ENVIRONMENT
AGENCY

Date : 17 May 2006

**Flood Risk Assessment - Proposed Mixed Use Development
Land South West of Bicester**

MIXED USE DEVELOPMENT AT LAND SOUTH WEST OF BICESTER

- SITE SURFACE WATER FLOW DIRECTION
- PROPOSED REALIGNMENT OF PINGLE BROOK

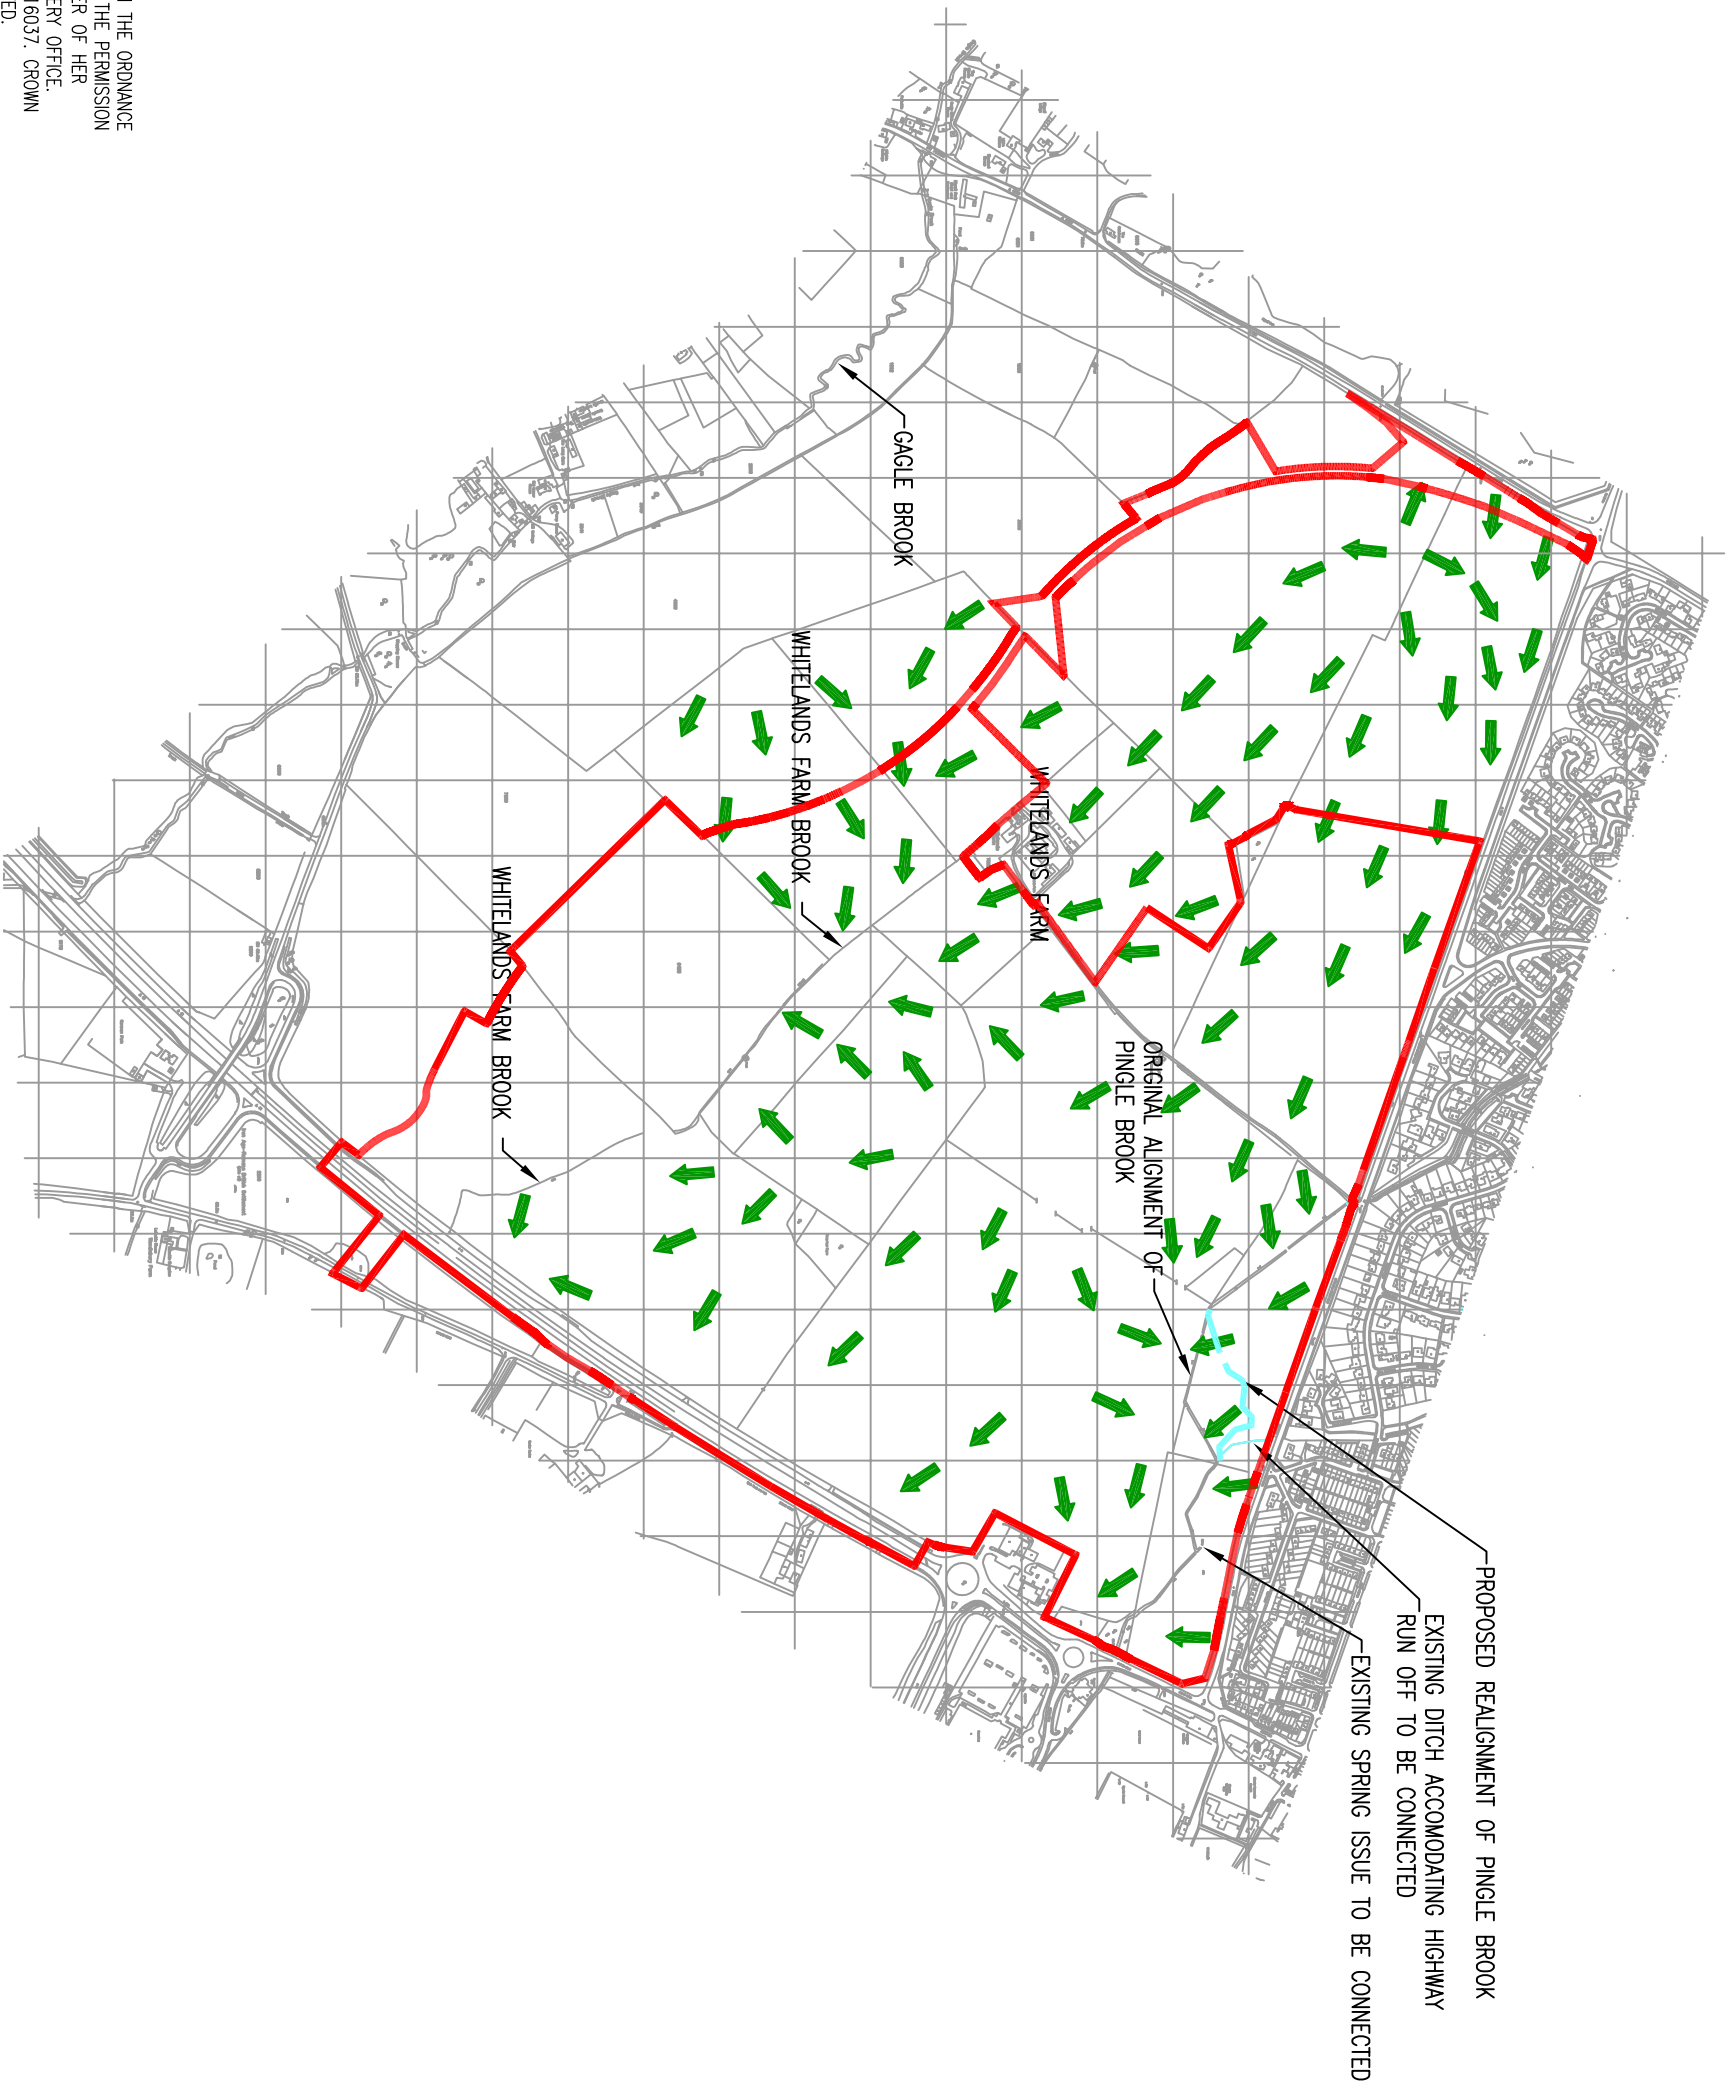
There is also reference to the diversion of a watercourse, it is not clear from the drawings whether this is part of the proposed layout. No details have been provided, or principles establishing the way in which any diversion will be undertaken.
